KITTITAS COUNTY COMMUNITY DEVELOPMENT SERVICES

RE: BL-18-00006 Garrison

TO: Community Development Services
FROM: Taylor Gustafson, Environmental/Transportation Planner 
DATE: June 1, 2018
SUBJECT: Garrison BL-18-00006

# BLA EXHIBIT

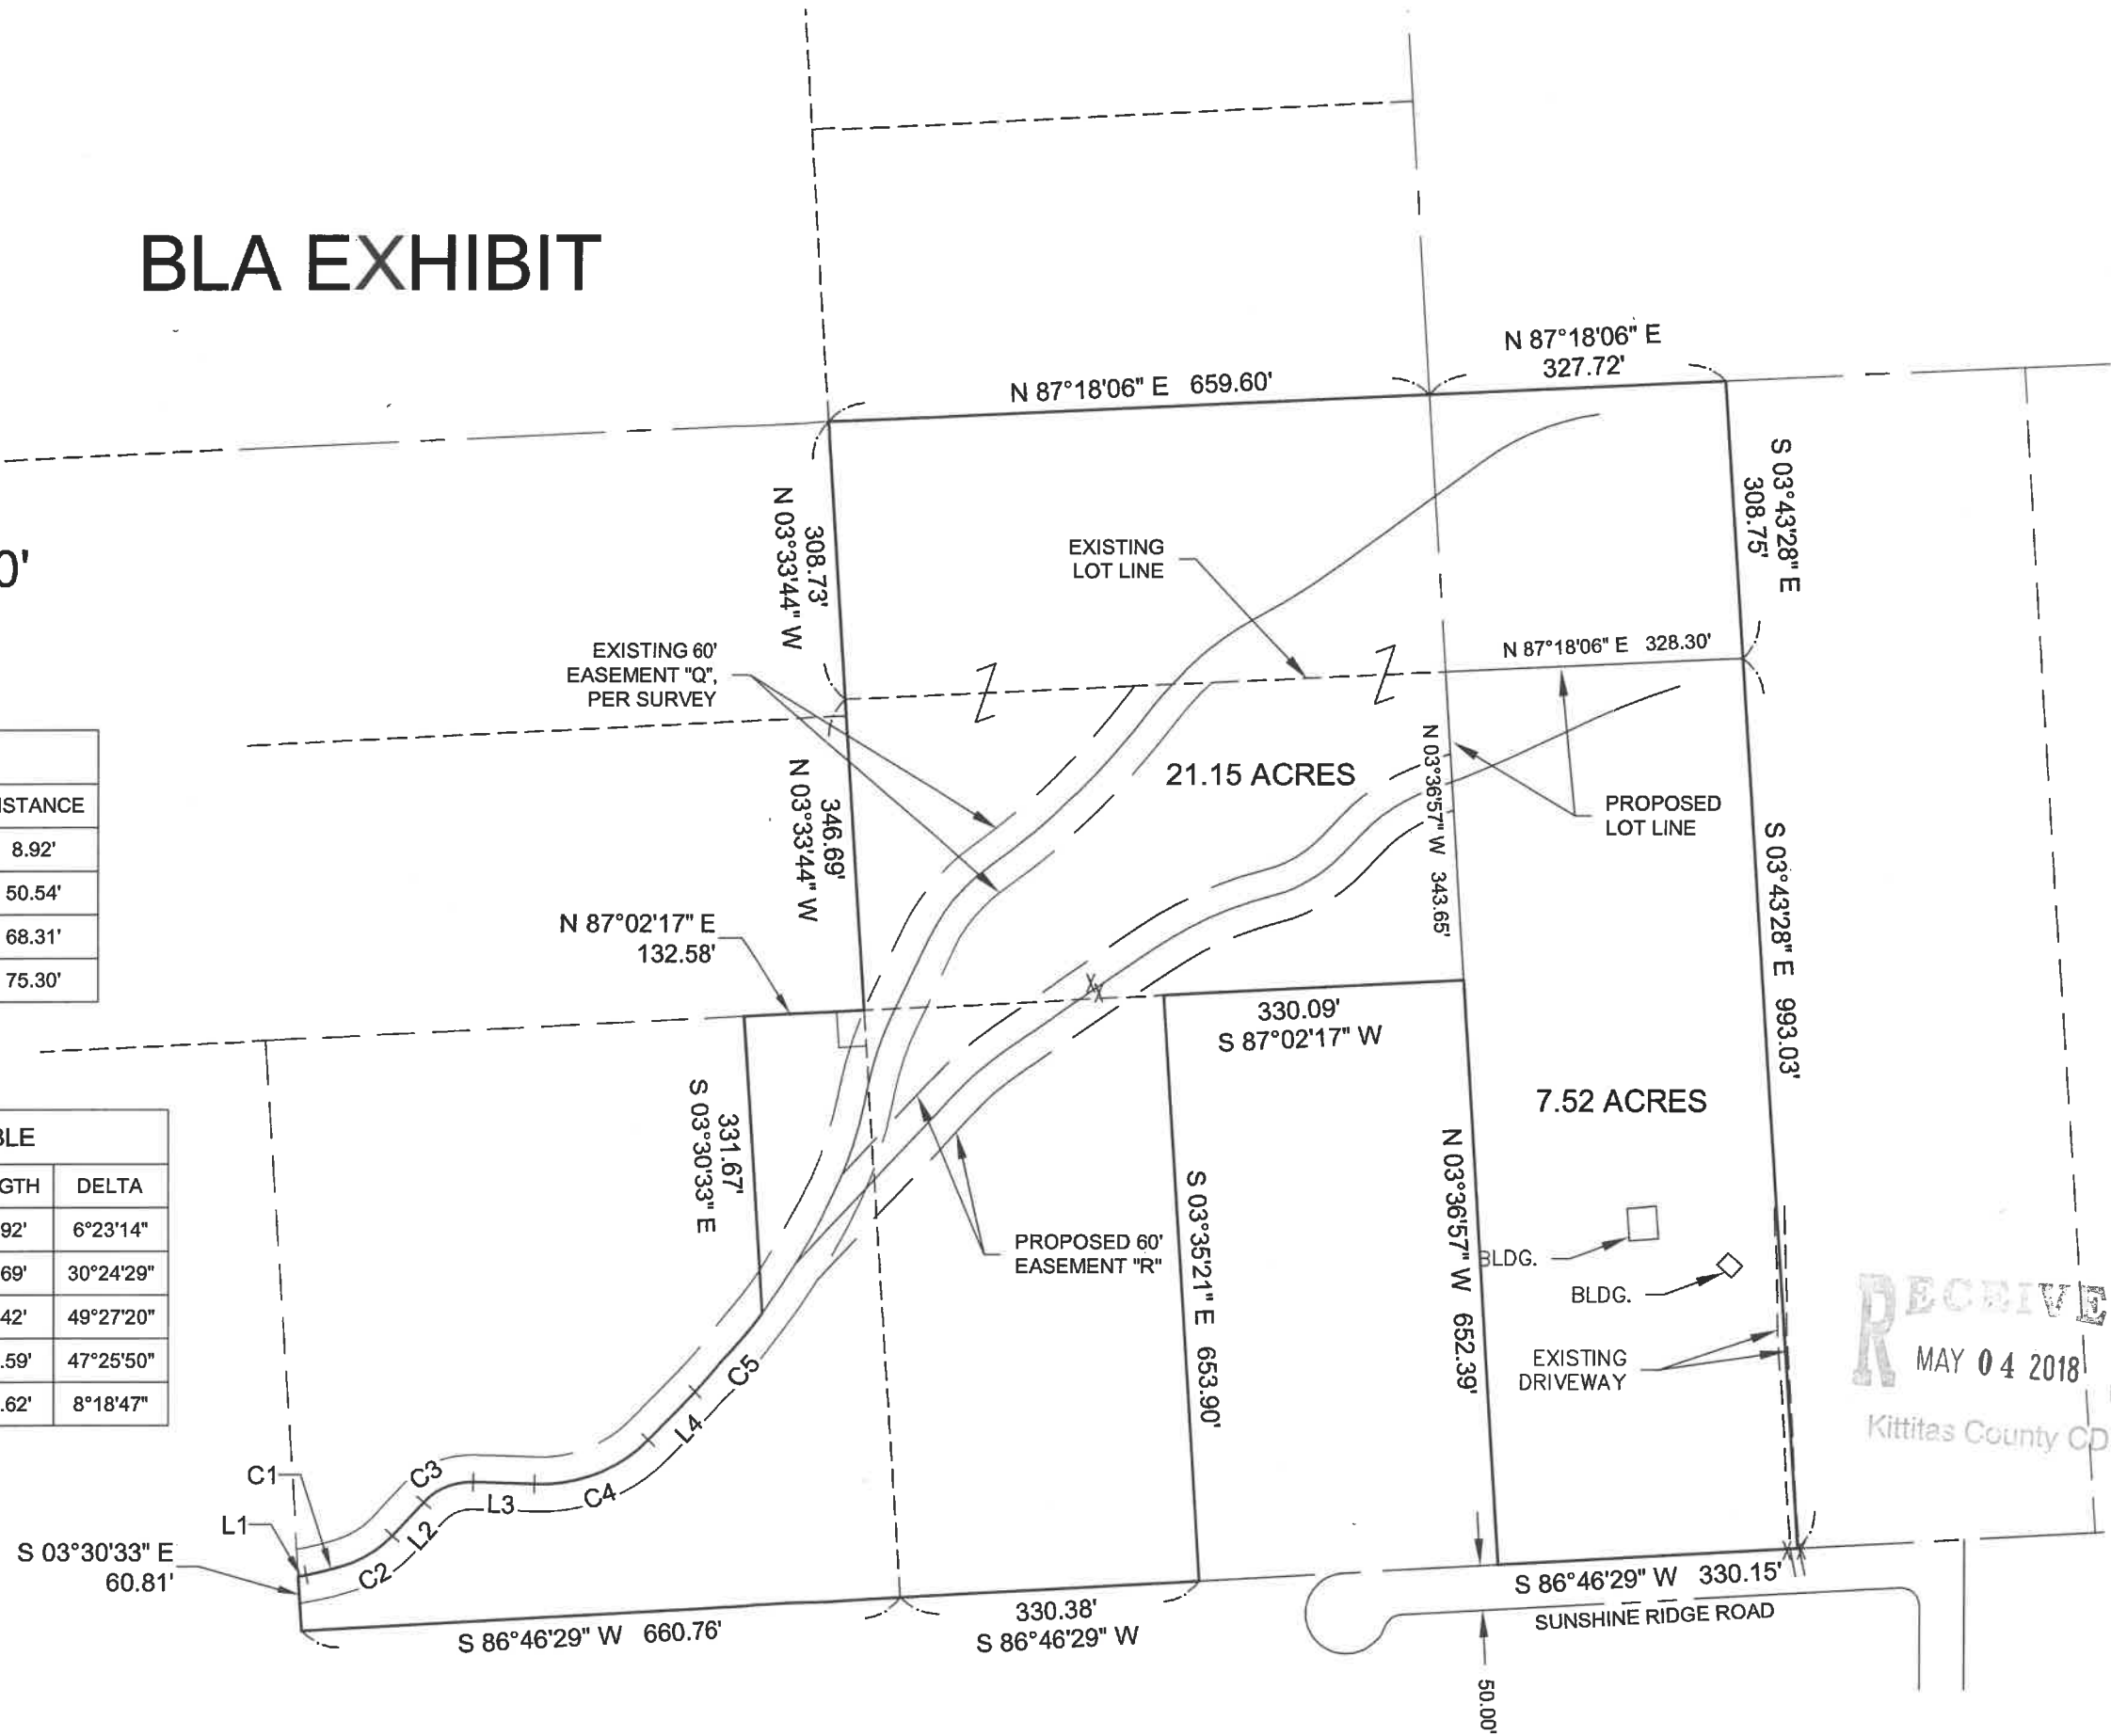
1. A revised legal description that describes the final configuration of the subject property shall be required.
2. A survey map for review
3. Show access easements on the face of the BLA including the cul-de-sacs.

I have reviewed this and feel that as long as Pub Works has no issues, I'm good with it. Does it meet all of the WUI requirements? The reason I mention this is because the map shows a "proposed" easement, but the aerial looks as though it's already done. If it's simply a lot-line adjustment, and the easement map was simply for reference, then I don't have an issue with it.

This response from the applicant is insufficient. I need an adequate site plan showing the location of the drainfield and septic tank. The applicant states, "The tank is about 50 feet west and south of my building," but which of the two buildings is he referring to? He also states that "T" posts mark the ends of the drainfield lines. Does this mean we are supposed to make a field visit to gain information that should have been provided?

Find below correspondence from our Environmental Health department in regard to the proposed BLA. The comment period officially ends May 31st, and it would expedite the process if a revised site plan were submitted with sufficient time to review before then. The site plan requires the addition of all existing wells, septic, and drainfields to ascertain whether the BLA observes all necessary setbacks.

In the project narrative of this boundary line adjustment application it is stated, "Sewage is disposed of via existing septic tanks and drainfields." Buildings are shown on the site plan but no existing septic systems are shown. Are there any that should be? Are there any existing wells that should be shown?

There is no well. We are on Sky Meadows water system. The septic system was constructed with a county permit and there should be a plan on file. Our project engineer is out until next week. The septic tank is about 50 feet west and south of my building. The ends of the drain field are marked with steel T-posts.
